**SSD-45024776 – Narwee Parklands Seniors Housing at 59-67 Karne Street North, Narwee**  
**Submission to the State Significant Development Application – Canterbury Bankstown City Council**

**Attachment A**  
**State Significant Development Application SSD-45024776 – Canterbury Bankstown**  
**Council Submission**  
**59-67 Karne Street North, Narwee**

Figure 13 - PMF Level & Depth – Proposed Conditions

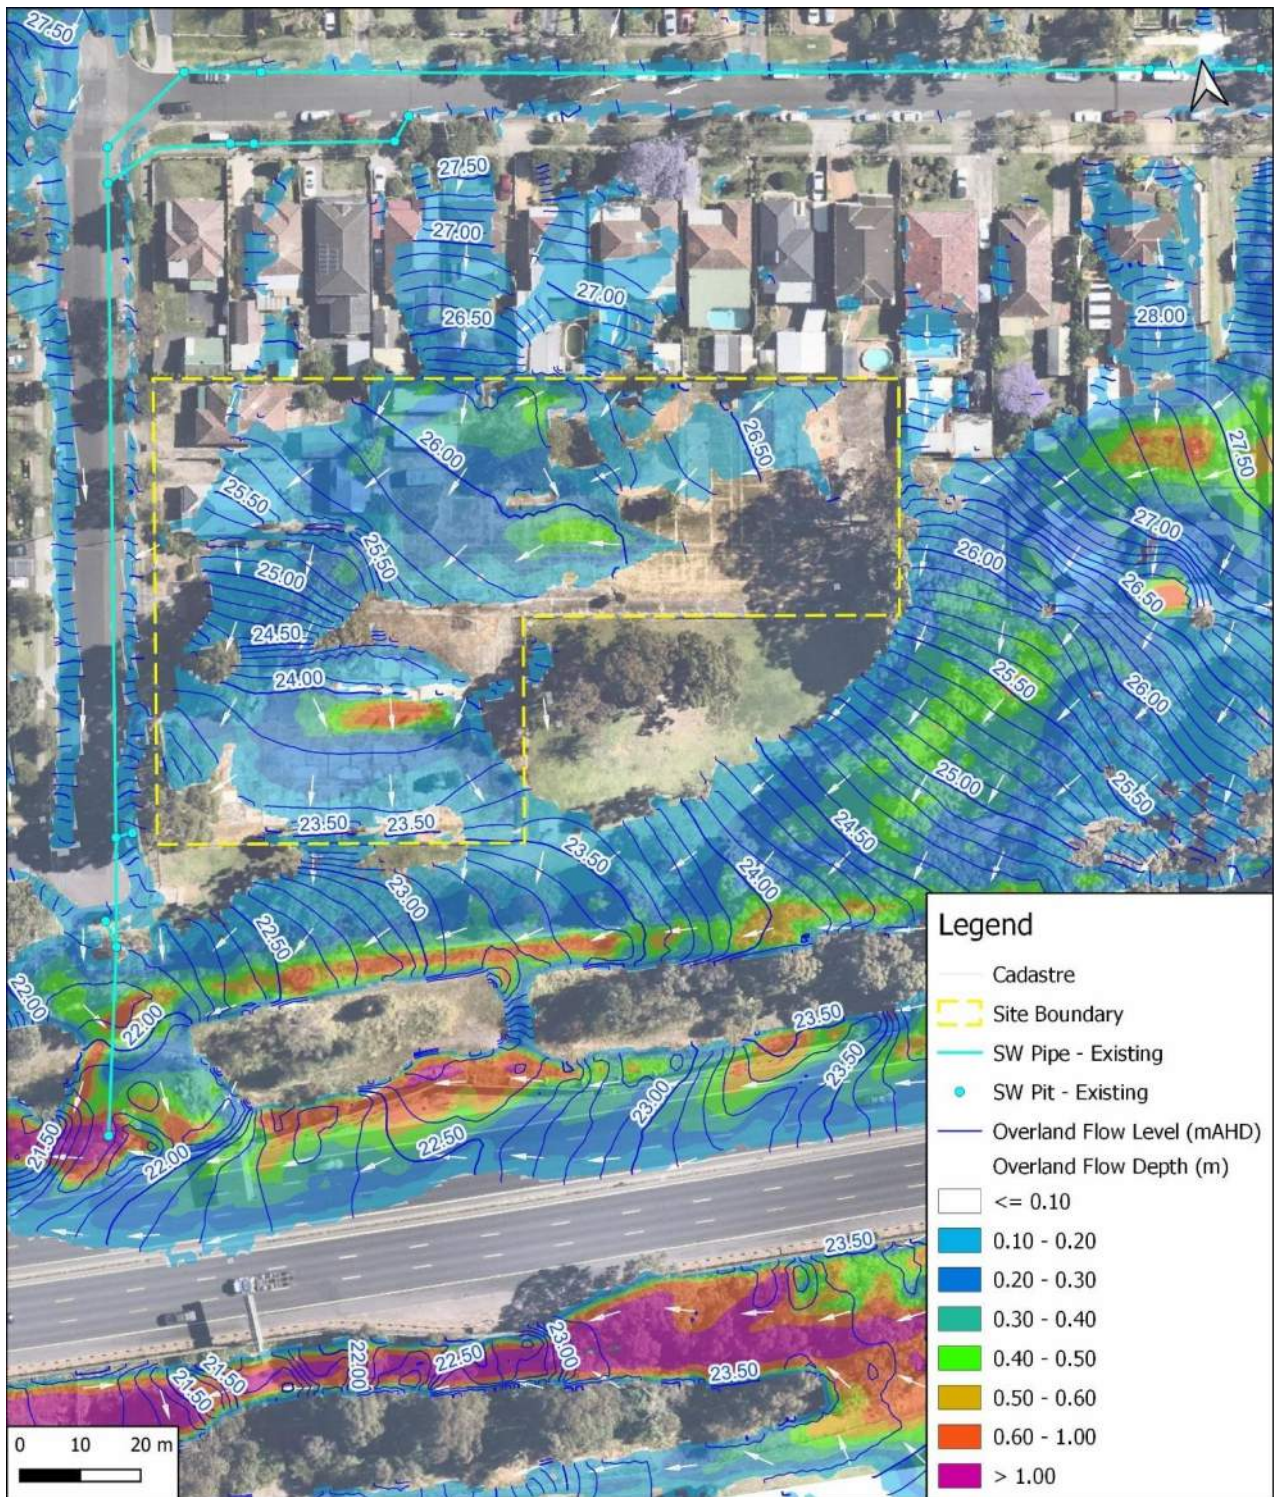
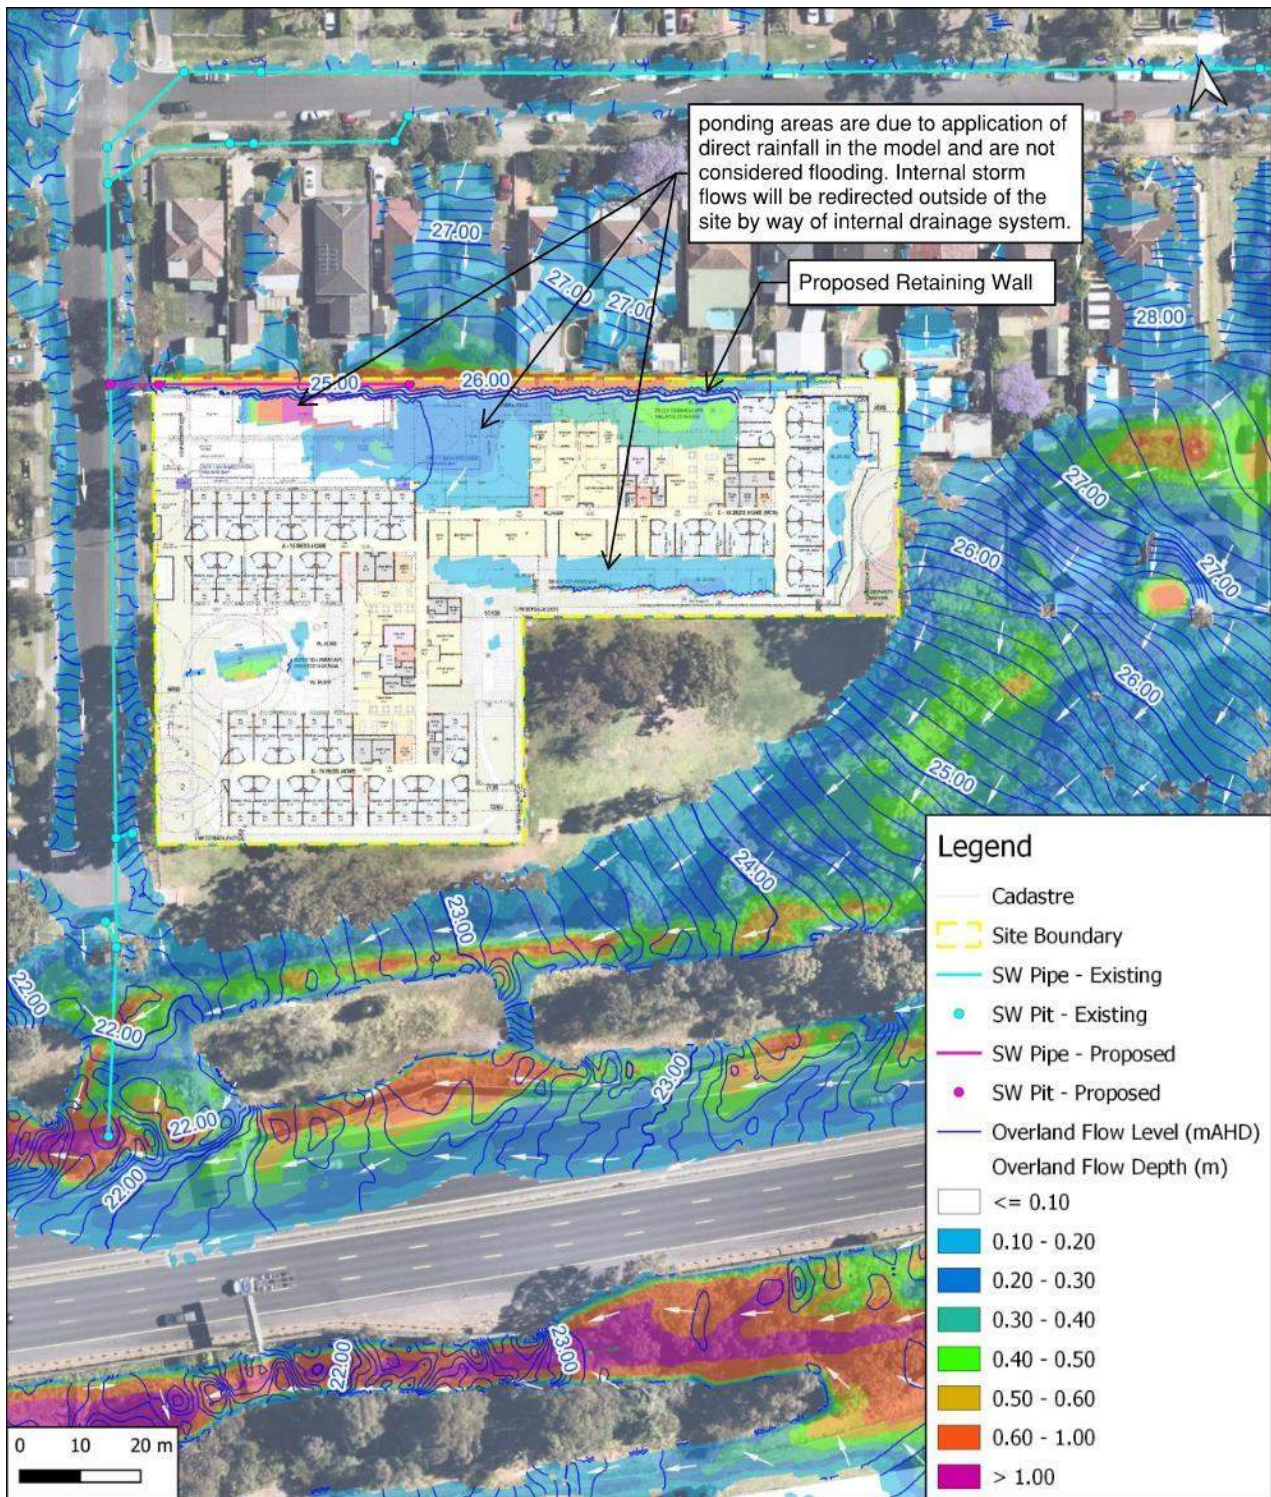
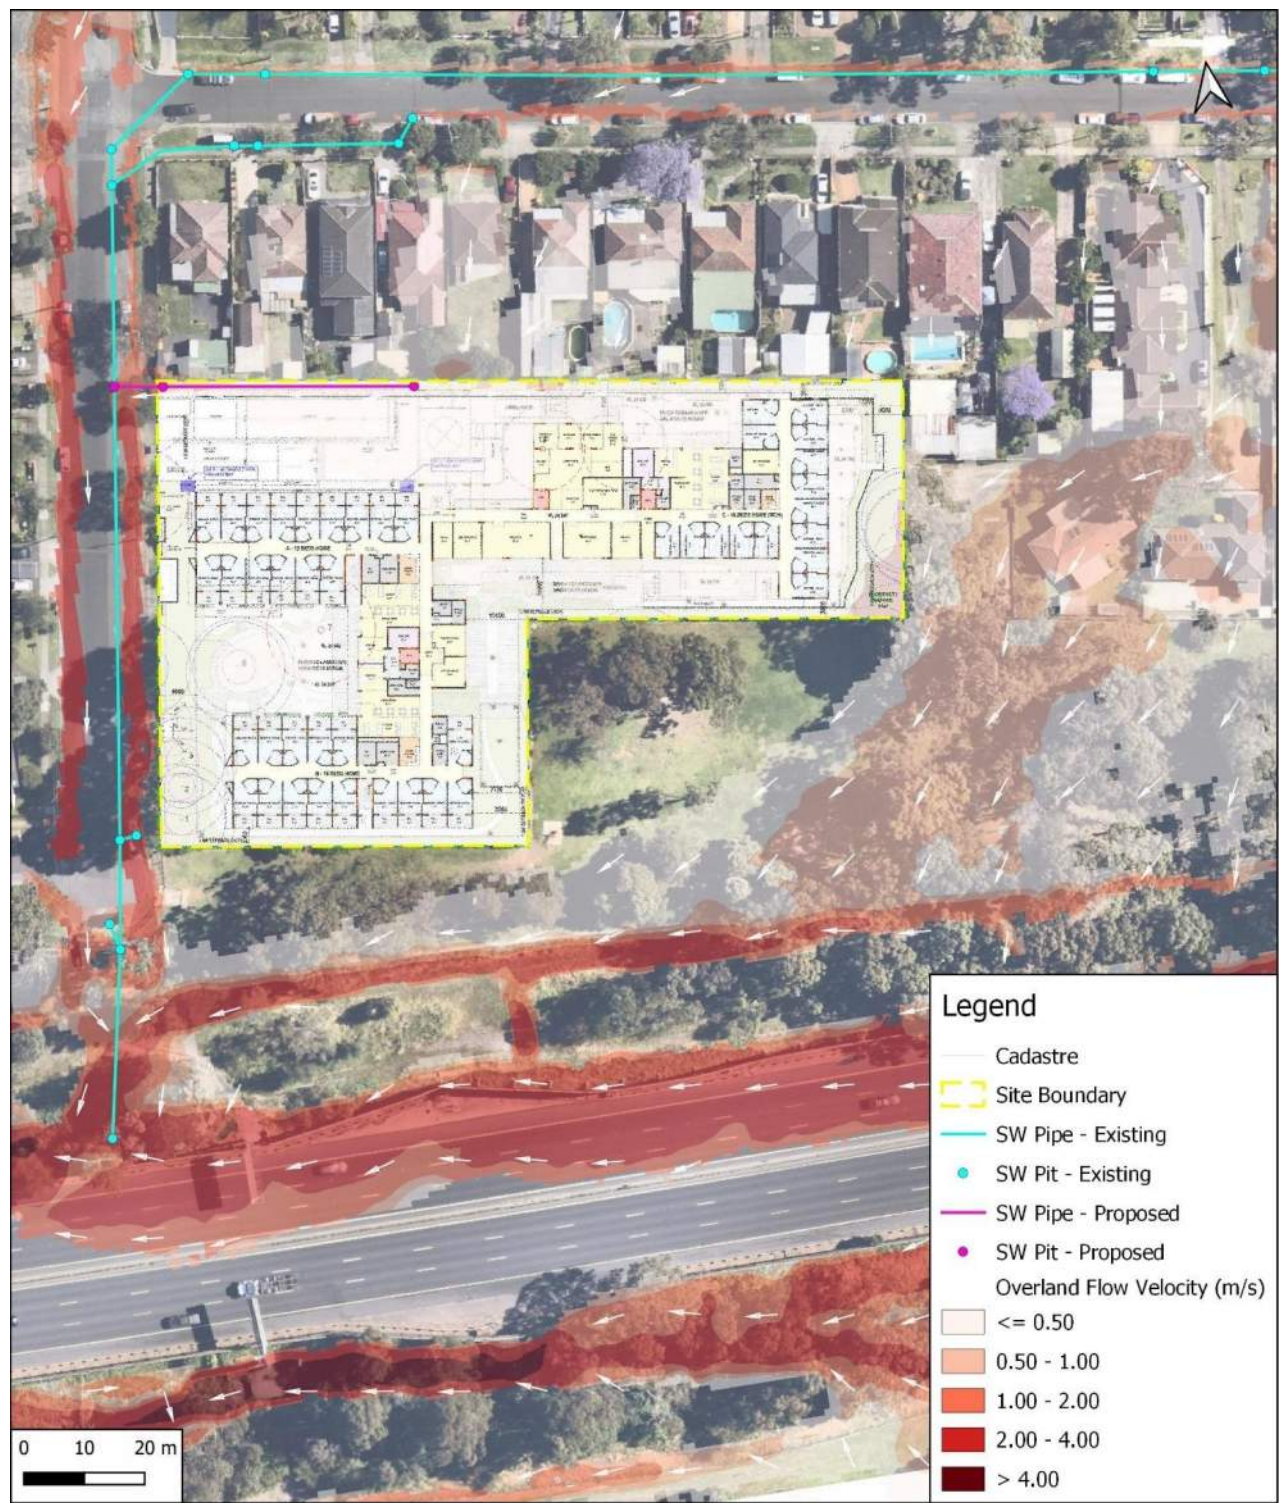
- 3) Update the Flood Impact Assessment with revised peak flow figures, demonstrate the proposal does not worsen flooding conditions and provide a flood emergency evacuation plan

| Item       | Council Feedback                                                                                                                                                                                                                                                                                                                                                                                                                                                                                                                                                                                                                                                                                                                                                                                                                                                                                                                                                                                                                                                                                                                                                                            |
|------------|---------------------------------------------------------------------------------------------------------------------------------------------------------------------------------------------------------------------------------------------------------------------------------------------------------------------------------------------------------------------------------------------------------------------------------------------------------------------------------------------------------------------------------------------------------------------------------------------------------------------------------------------------------------------------------------------------------------------------------------------------------------------------------------------------------------------------------------------------------------------------------------------------------------------------------------------------------------------------------------------------------------------------------------------------------------------------------------------------------------------------------------------------------------------------------------------|
| Flooding   | <p>As per the flood assessment produced by TTW NSW, the existing peak flow entering from the northern site boundary is up to 190m<sup>3</sup>/sec in the 1% AEP event (page 10). Yet the PMF event is noted as 2.3m<sup>3</sup>/sec. A flow of 190m<sup>3</sup>/sec is considered to be an error as the volumes are too high for this site. The existing peak flood levels should be reviewed and revised with the correct volume figures.</p> <p>Given the above, the proposed development does not adequately demonstrate consistency with the Bankstown Development Control Plan 2015, DES and the NSW Floodplain Development Manual. Moreover, the development will need to demonstrate no worsening of flood conditions as a result of the proposal.</p> <p>It is requested that a development consent condition is included by the Department for a Flood Emergency Management Plan and evacuation routes endorsed by the State Emergency Service (SES) to be provided prior to any Construction Certificate being issued.</p>                                                                                                                                                        |

**Figure 8 Proposed ground floor plan**

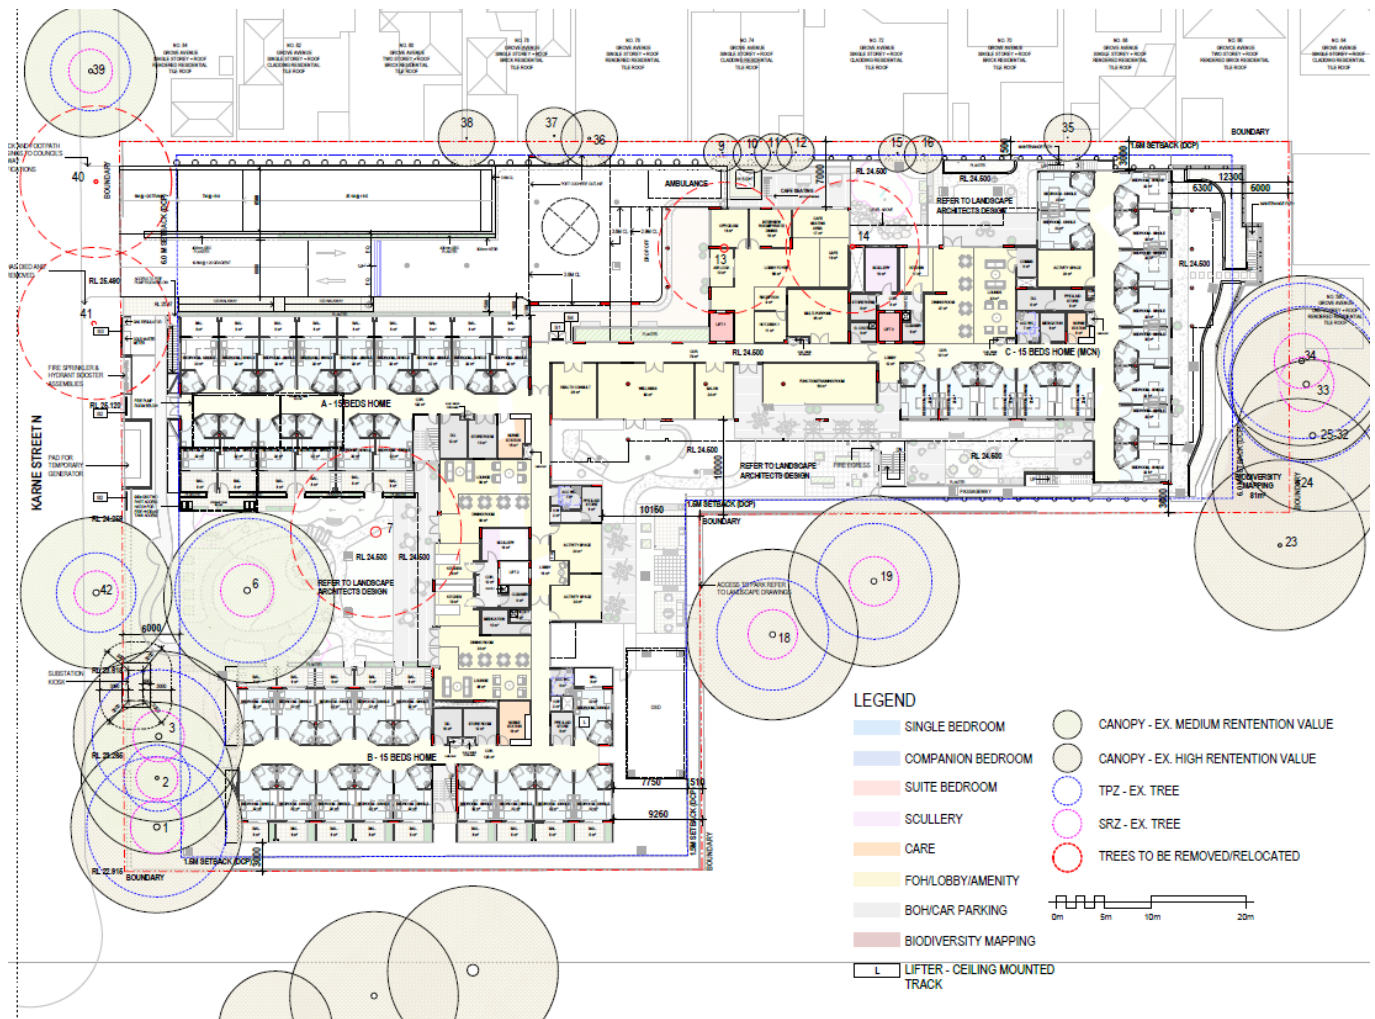
| Item       | Council Feedback                                                                                                                                                                                                                                                                                                                                                                                                                                                                                                                                                                                                                                                                                                                                                                                                                                                                                                                                                                                                                                                                                                                                                                            |
|------------|---------------------------------------------------------------------------------------------------------------------------------------------------------------------------------------------------------------------------------------------------------------------------------------------------------------------------------------------------------------------------------------------------------------------------------------------------------------------------------------------------------------------------------------------------------------------------------------------------------------------------------------------------------------------------------------------------------------------------------------------------------------------------------------------------------------------------------------------------------------------------------------------------------------------------------------------------------------------------------------------------------------------------------------------------------------------------------------------------------------------------------------------------------------------------------------------|
| Waste      | <p>The plans need to be amended to clarify the following:</p> <ul style="list-style-type: none"> <li>• The location of the bin collection point must allow for a Heavy Rigid Vehicle (HRV) to enter and exit in a forward direction. All movements must comply with the Australian Standard AS2890.2</li> </ul>                                                                                                                                                                                                                                                                                                                                                                                                                                                                                                                                                                                                                                                                                                                                                                                                                                                                             |

| Item                              | Council Feedback                                                                                                                                                                                                                                                                                                                                                                                                                                                                                                                                                                                                                                                                                                                                                                                                                   |
|-----------------------------------|------------------------------------------------------------------------------------------------------------------------------------------------------------------------------------------------------------------------------------------------------------------------------------------------------------------------------------------------------------------------------------------------------------------------------------------------------------------------------------------------------------------------------------------------------------------------------------------------------------------------------------------------------------------------------------------------------------------------------------------------------------------------------------------------------------------------------------|
|                                   | <ul style="list-style-type: none"> <li>• Demonstrate a HRV can service the site without hindering traffic flow (i.e., the full length of the HRV must be contained within the loading bay while still allowing a 2-metre rear clearance and not be located within the driveway area).</li> <li>• Headroom allowances compliant with AS2890.2 for the entire travel path.</li> <li>• Swept paths need to demonstrate HRV movements in addition to the provided B85 vehicle.</li> </ul> <p>Furthermore, the documentation needs to be updated to increase the bin allocation in line with EPA generation rates:</p> <ul style="list-style-type: none"> <li>• 9 x 1,100L bulk garbage bins</li> <li>• 4 x 1,100L bulk recycling bins</li> </ul> <p>Both garbage and recycling are to be collected weekly by a private contractor.</p> |
